## **Cherwell District Council: Begbroke Science Park - Section 96A Application for Non-Material Amendments to Reserved Matters Approval ref. 21/03150/REM**

On behalf of our client, Begbroke Oxford Limited (BOL), Lichfields has submitted today via Planning Portal (PP-12220159) an application for Non-Material Amendments to Reserved Matters Approval (Ref. 21/03150/REM) (dated 27<sup>th</sup> January 2022) for:

Drawing
Proposed Section AA

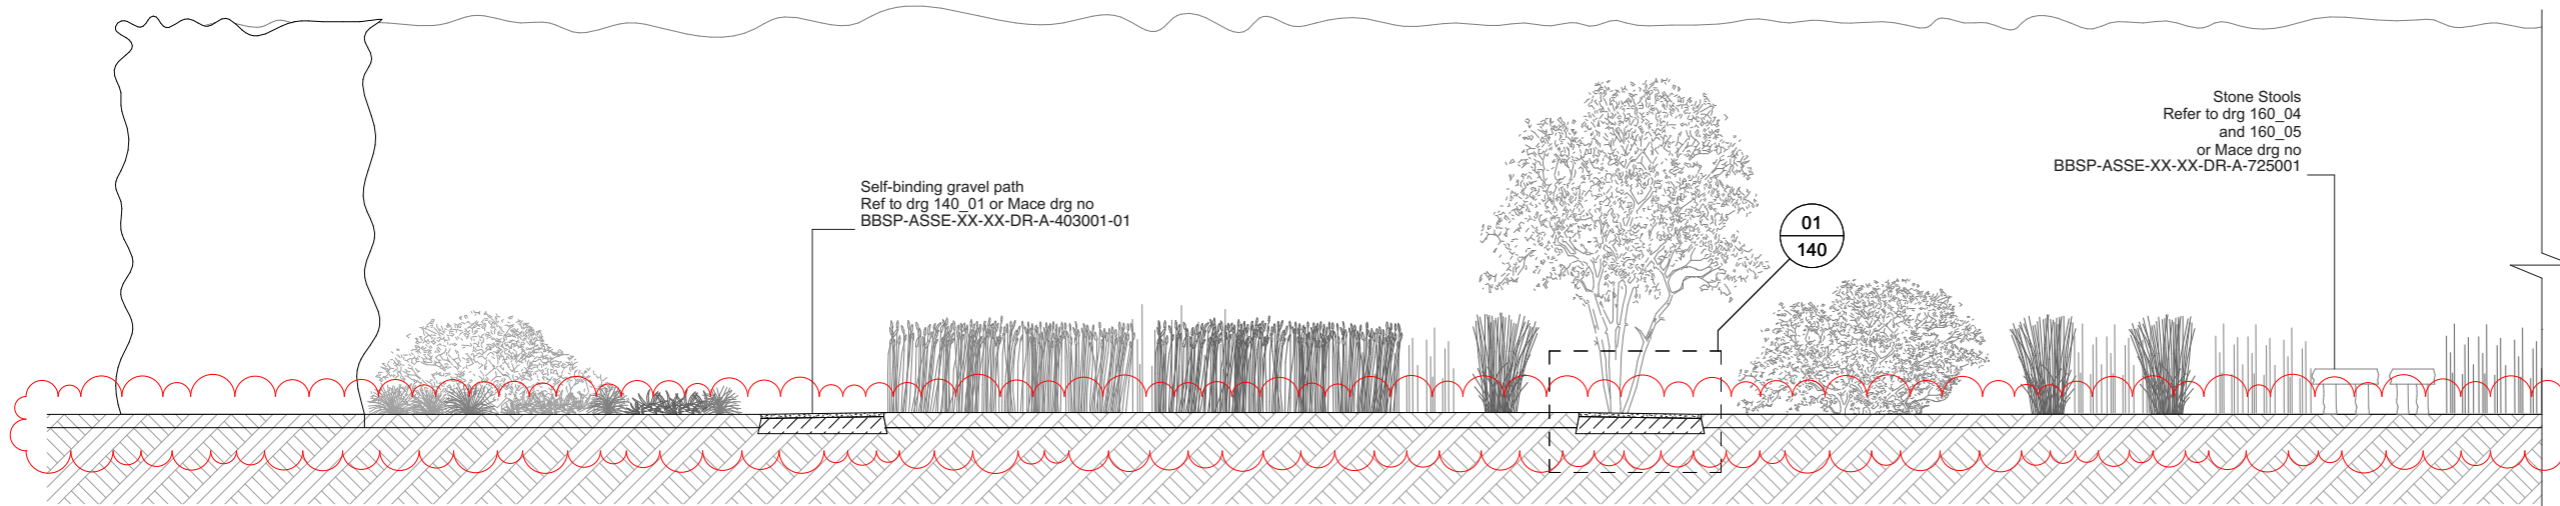
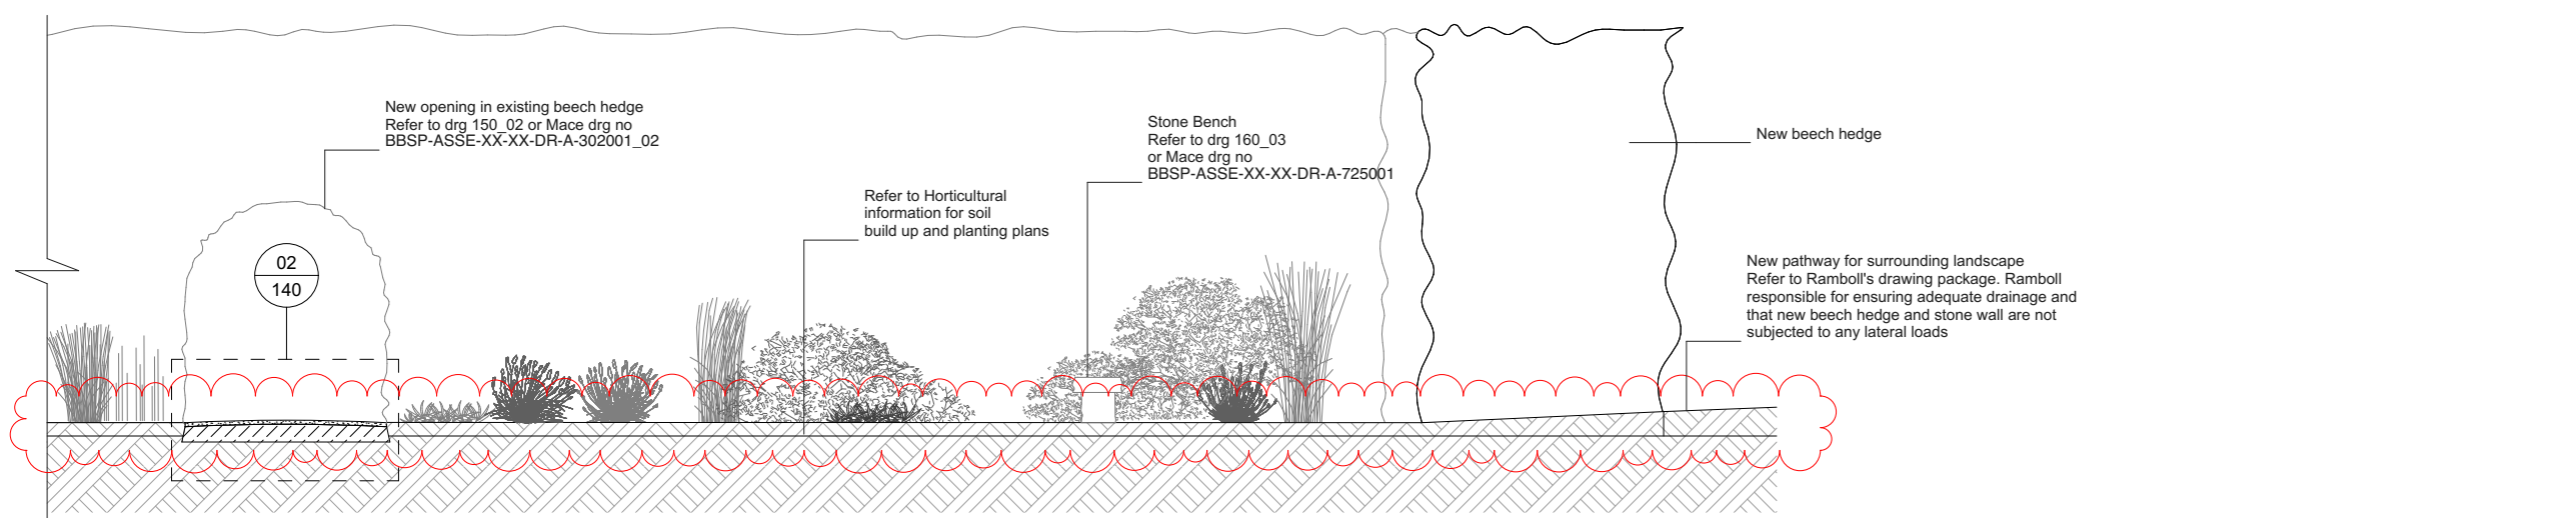
The design and setting out of the weed garden<sup>1</sup> has also evolved during the detailed design stage from that approved with the Reserved Matters submission and amended slightly by the June 2022 NMA. The minor changes are reflected on the updated drawings and it is also proposed that the drystone wall will be constructed with lime mortar instead to allow for a more robust wall.

DRAWING NAME:
**PROPOSED ELEVATIONS & SECTIONS -
ACADEMIC BUILDING SERVICES BUILDING**

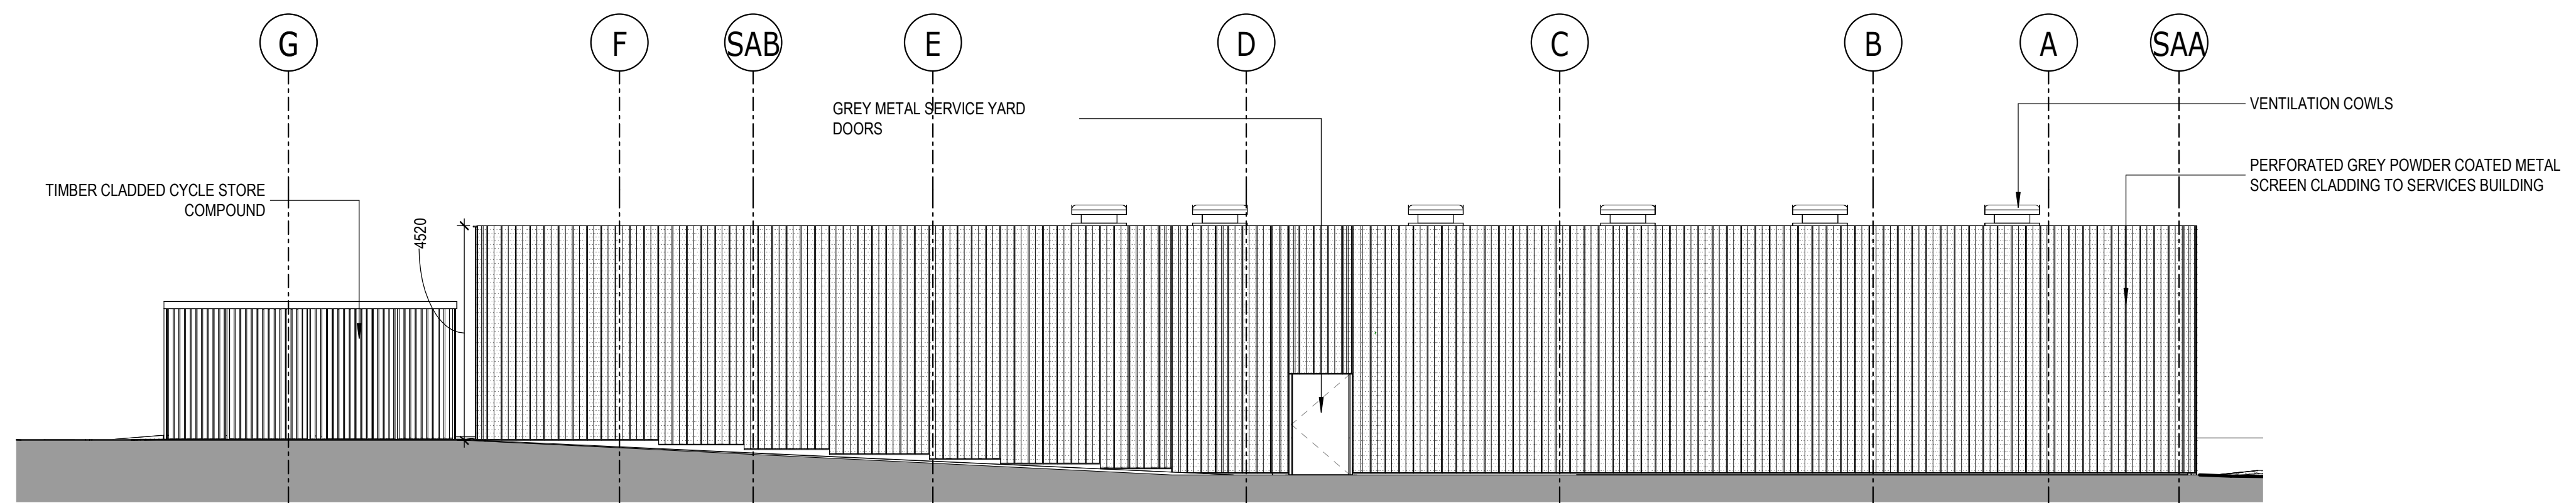
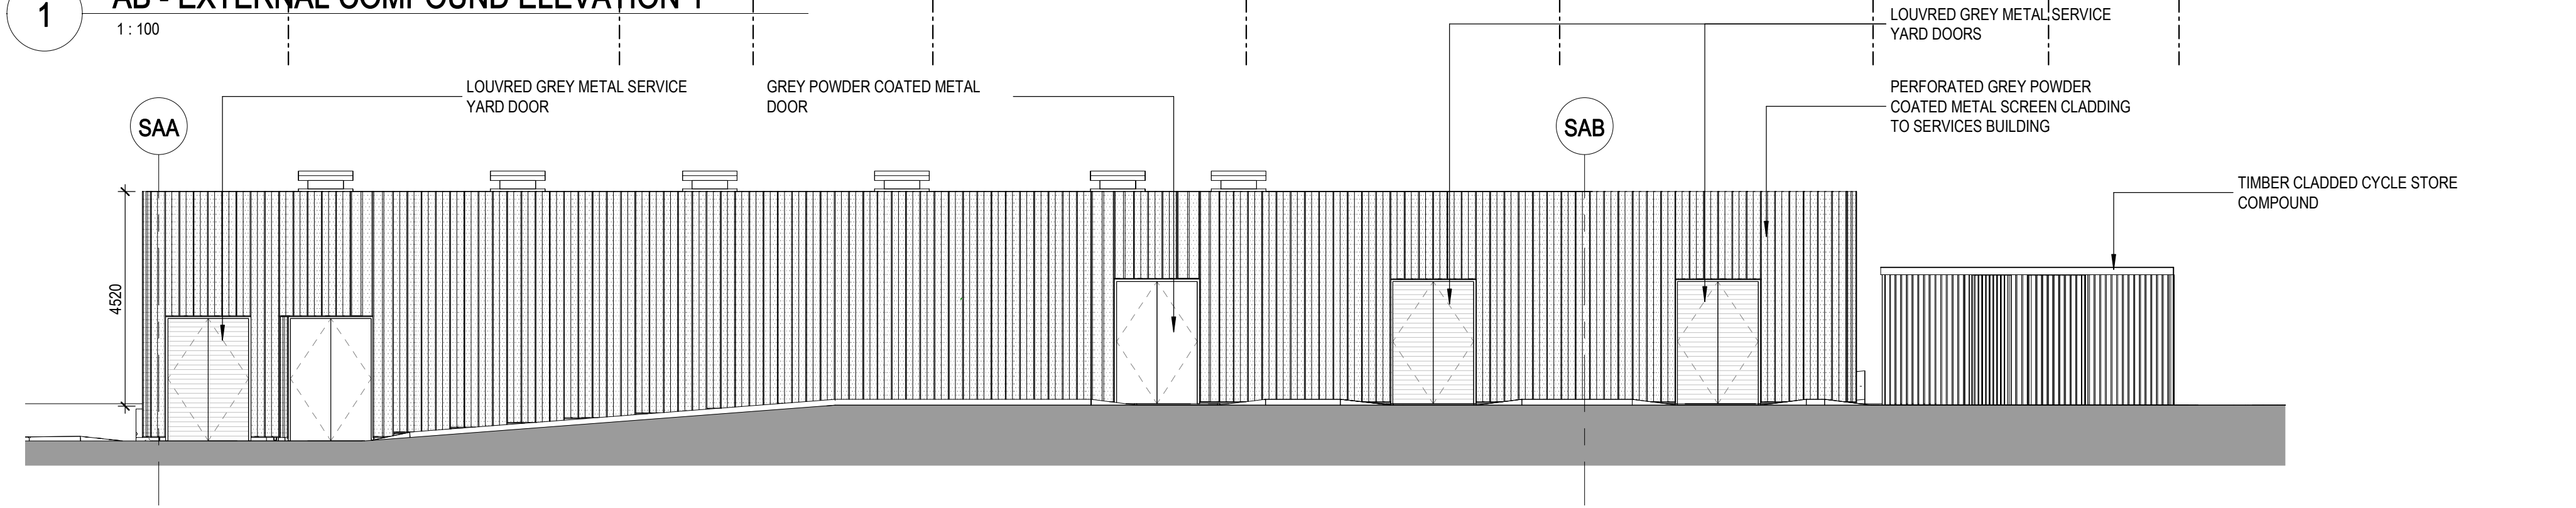
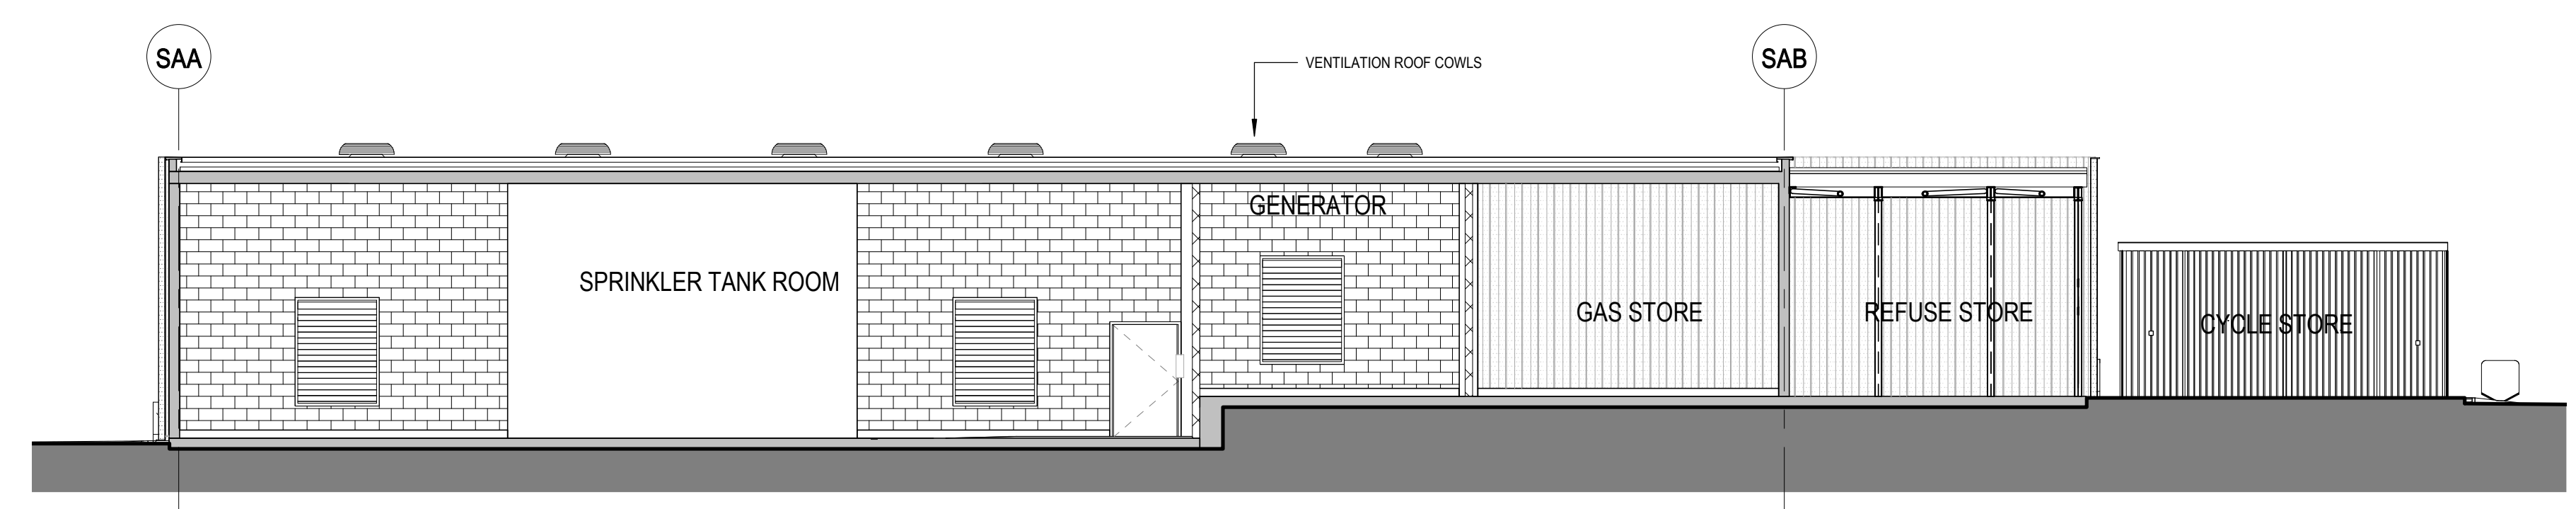
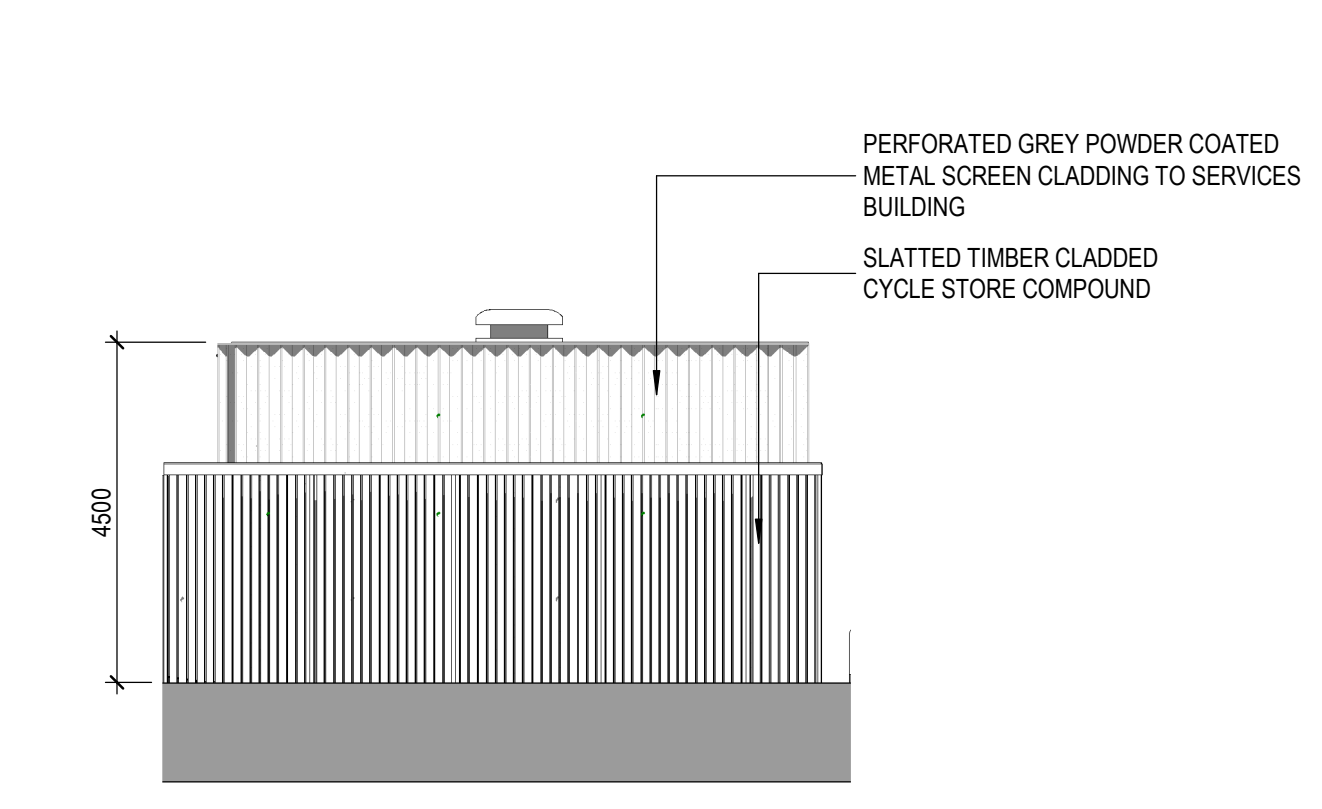
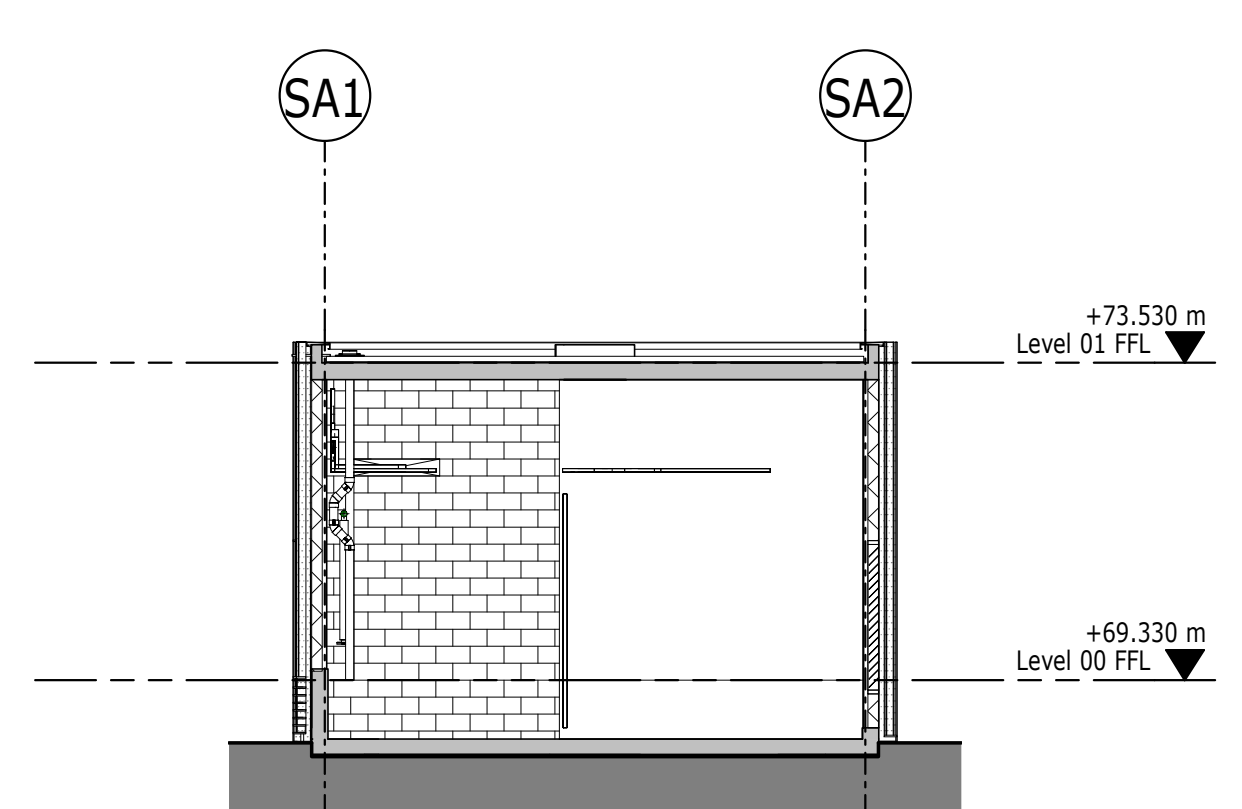
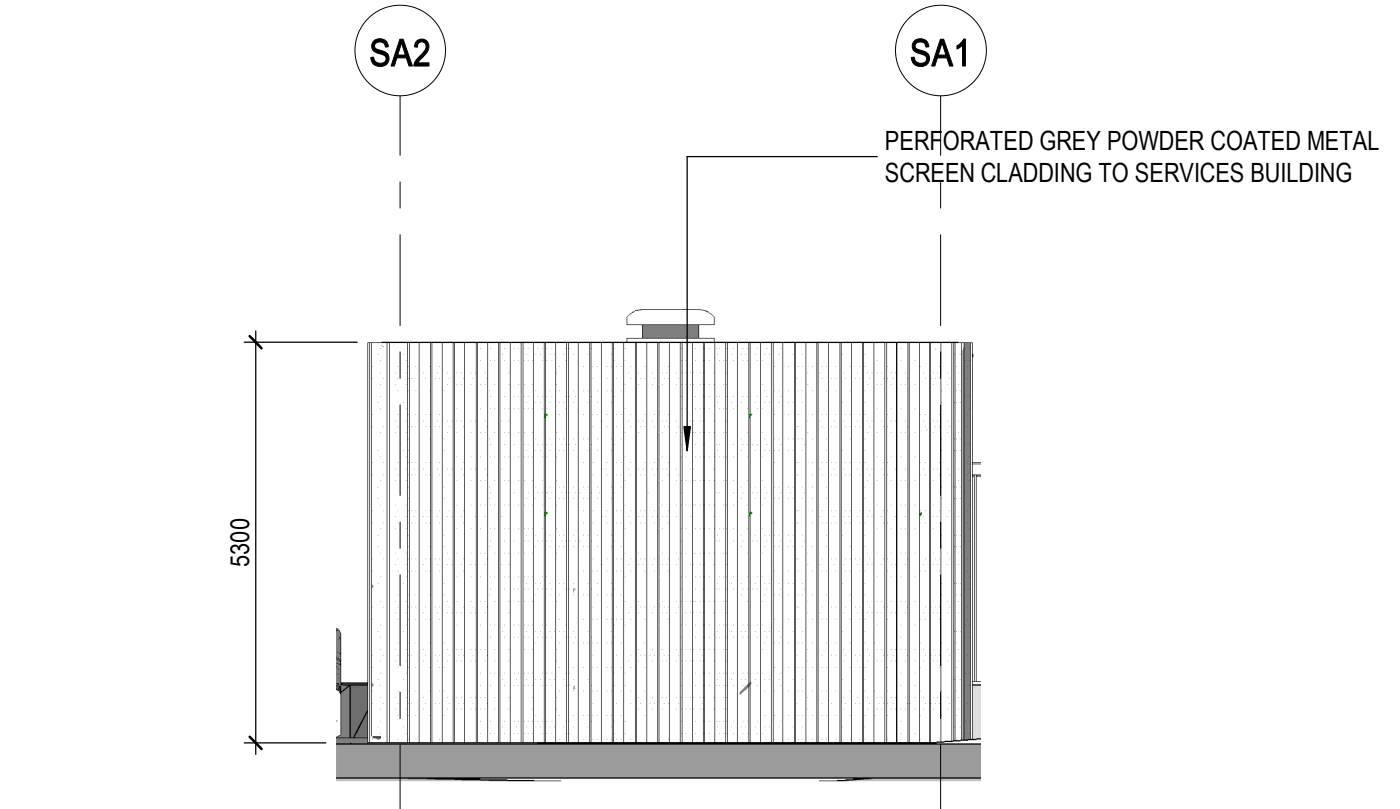
- 1 Roof cowls are proposed to be added to the Academic Building Services Building. Ventilation Grille cut-outs are to be removed from the perforated metal cladding panels and relocated to within the blockwork walls behind. One single door is to be moved from the West Elevation to East Elevation.
- 2 Enclosed roof plant and lift overrun massing on both buildings revised.
- 3 In respect of the entrance curtain wall of the Commercial Building, horizontal louvres are to be removed from ground floor elevation but retained on upper floors.
- 4 Minor updates to the compound massing and roofscape of the gas compounds of the Commercial Building.
- 5 Minor updates to the landscaping finishes albeit the overall landscape strategy remains unchanged.
